From: Joe Griffiths [REDACTED]
Sent: 22 February 2019 10:14
To: Sian Eggington
Subject: RE: Further Information Required on Your Ref: PP-07637507 Our Ref: AW/63/19/HH
Attachments: 19.007 - 030 Rev B Proposed Block Plan.pdf

From: Sian Eggington [REDACTED]
Sent: 22 February 2019 08:58
To: 'joe@atramarchitecture.co.uk'
Subject: Further Information Required on Your Ref: PP-07637507 Our Ref: AW/63/19/HH

Client	Steve King
Job title	31 Elizabeth Avenue Side Extension to Form Self Contained Annexe
Drawing title	Proposed Block Plan / Site Plan

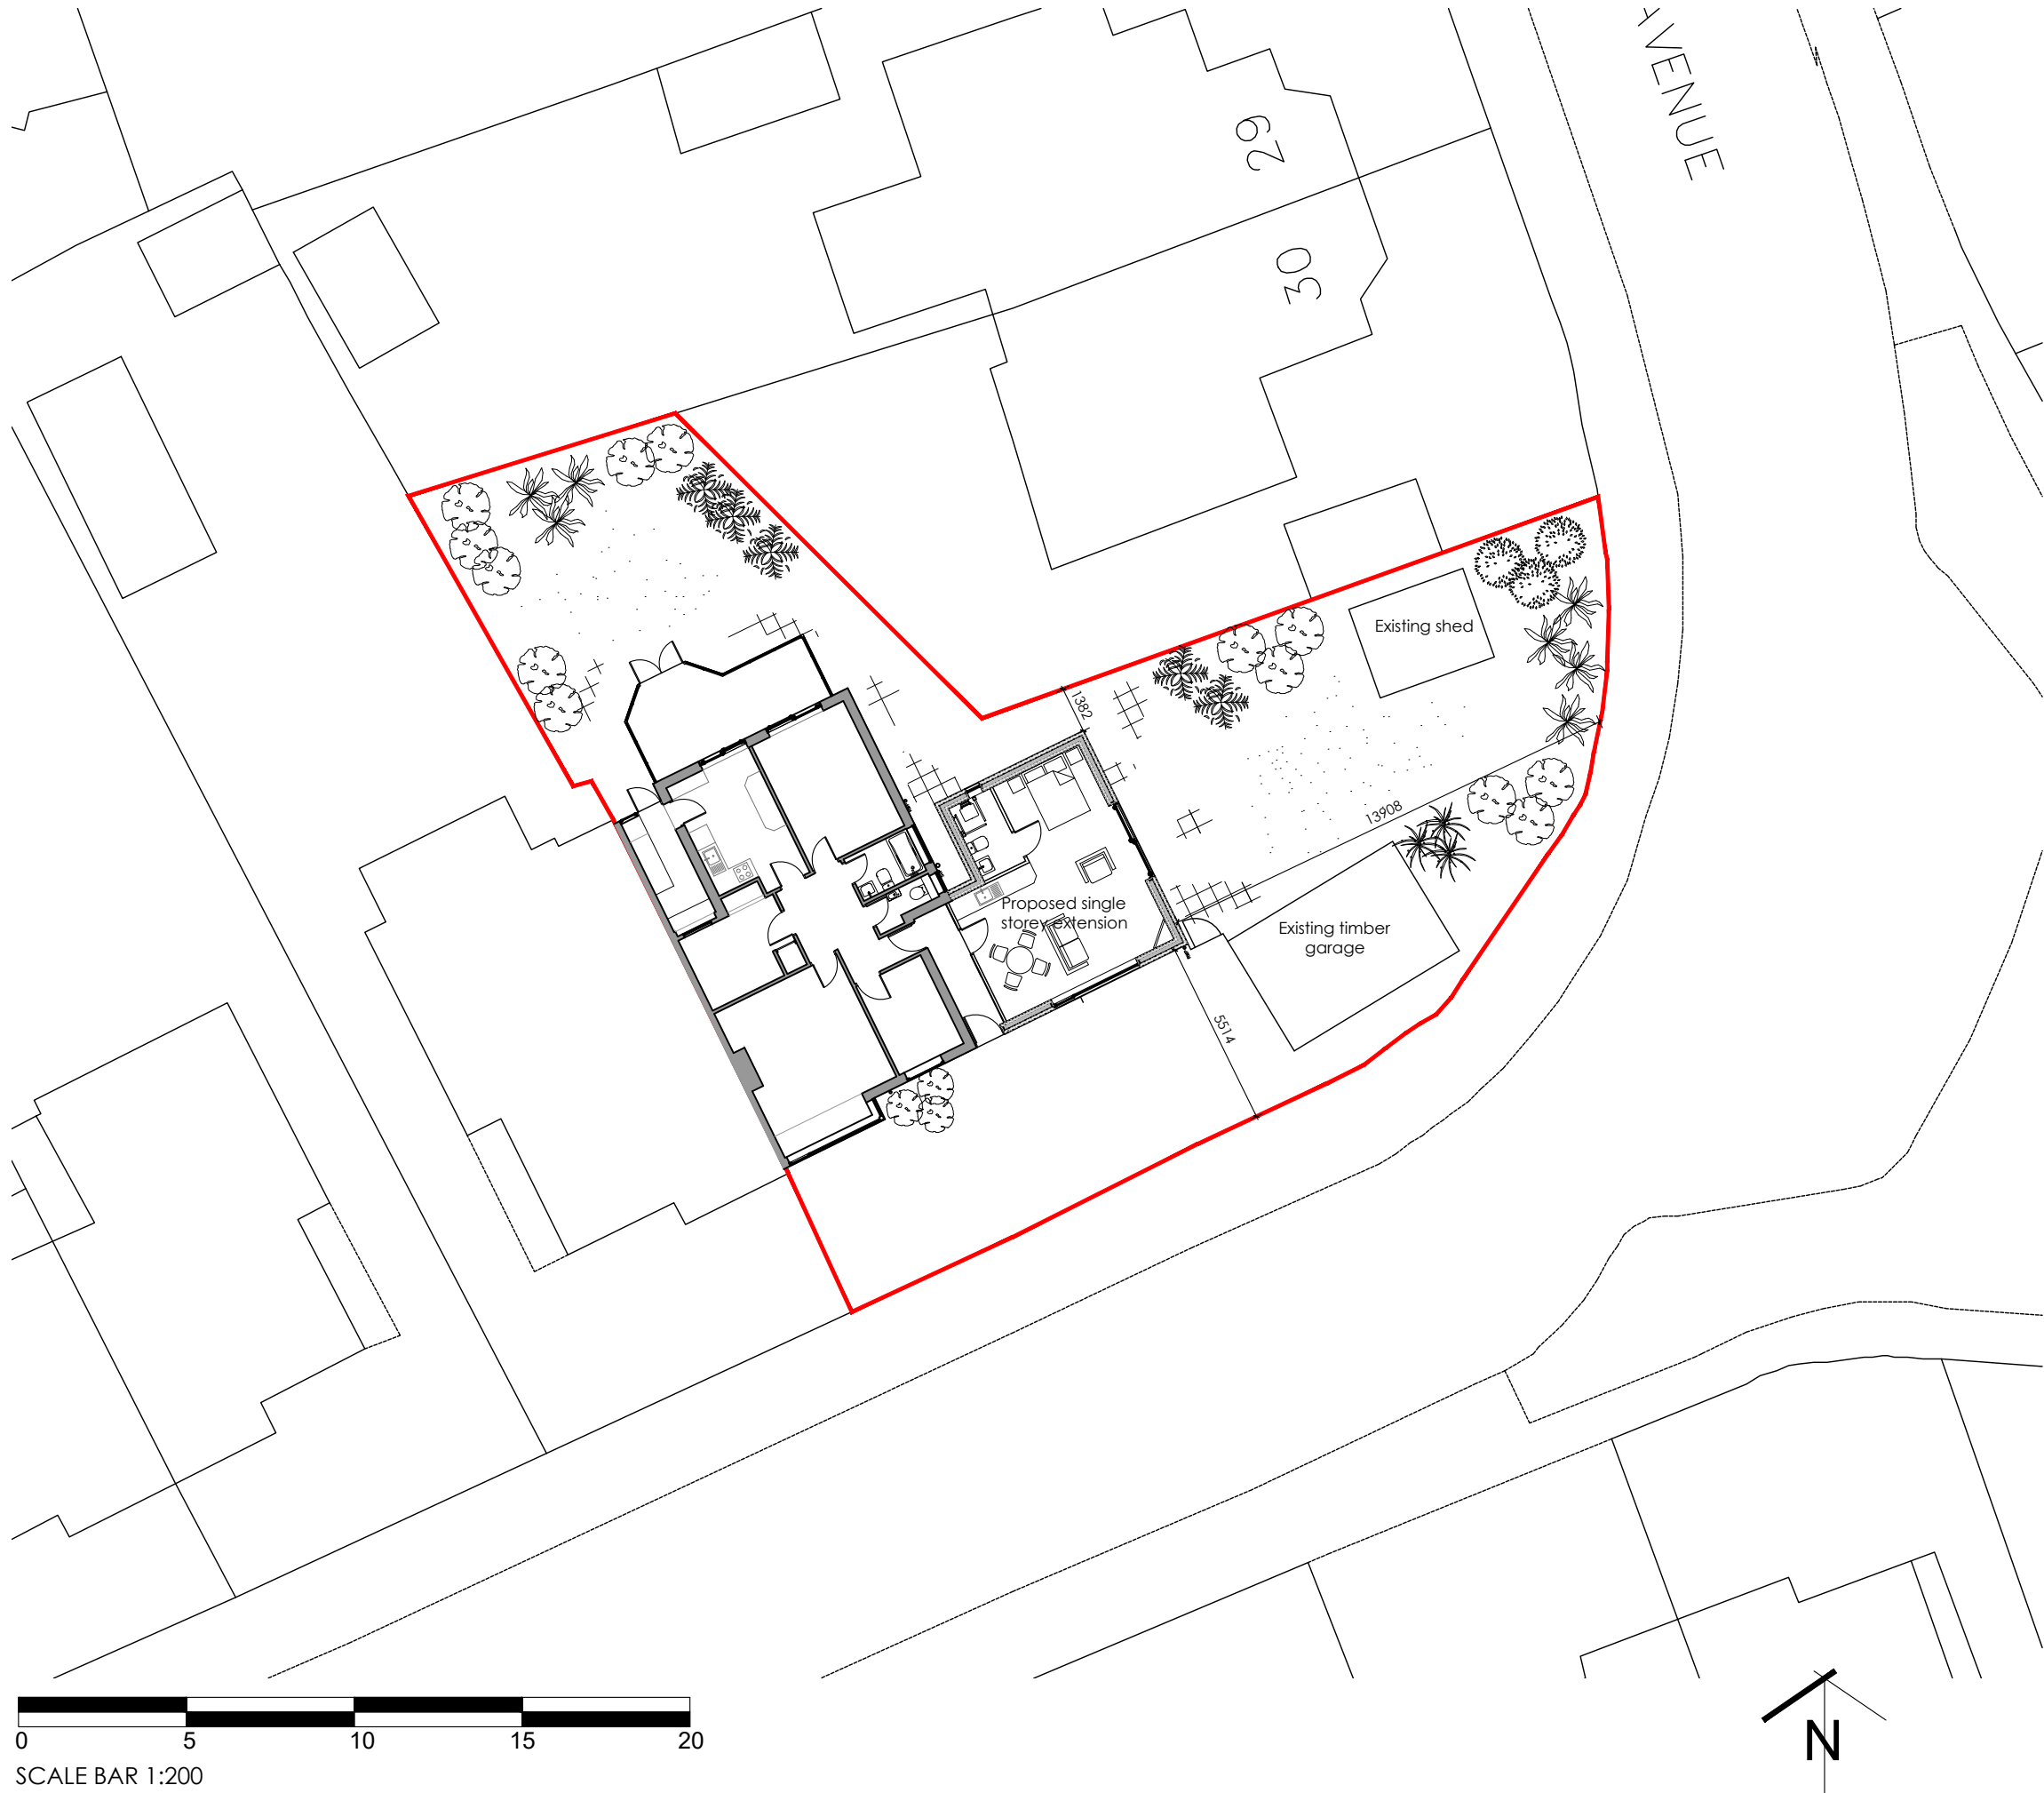
Thank you for your email. As stated in our letter we require dimensions to all site boundaries on the block plan(front/rear/sidex1). On the block plan you have provided there are no dimensions to the site boundaries. This is a local requirement by Arun council for all applications submitted to them.

Please find attached a revised block plan giving dimensions to the boundaries.
